STATE OF NORTH CAROLINA
DEPARTMENT OF TRANSPORTATION

June 13, 2007

Addendum No. 1

RE: Contract ID: C201749
WBS# 40248.3.GV1
F. A. # IMS-40-3 (119) 148
Orange, Alamance Counties (I-4918)
I-40 / I-85 From NC-54 (MP 148) In Alamance County to
West of SR-1114 (Buckhorn Rd.) in Orange County

PROJECT NO.	SHEET NO.	TOTAL SHEETS
40248.3.GV1 (I-4918)	4	6

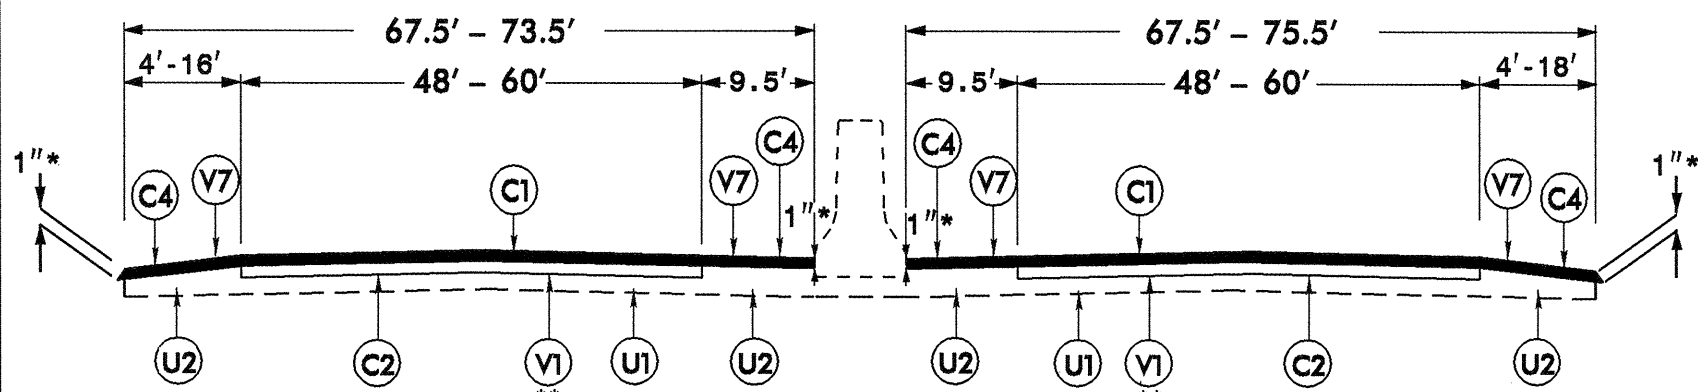
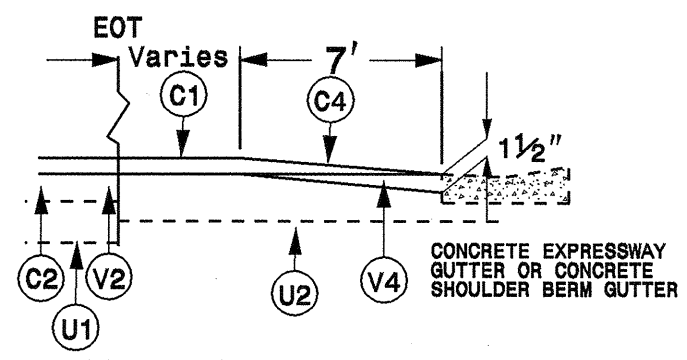
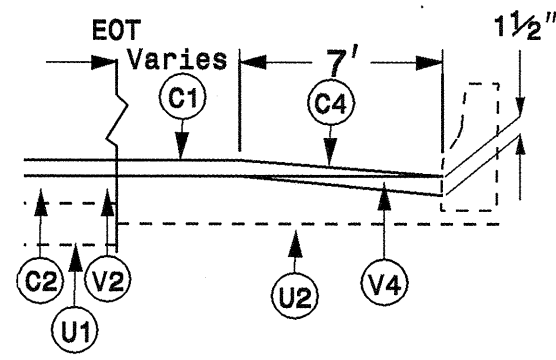
On Sheet No. 4, the Typical Sections have been revised to change the Shoulder Pavement Design from ACSC Type S9.5D to ACSC Type S9.5B. Please void Sheet No. 4 in your Sketch Maps and staple the revised Sheet No. 4 thereto.
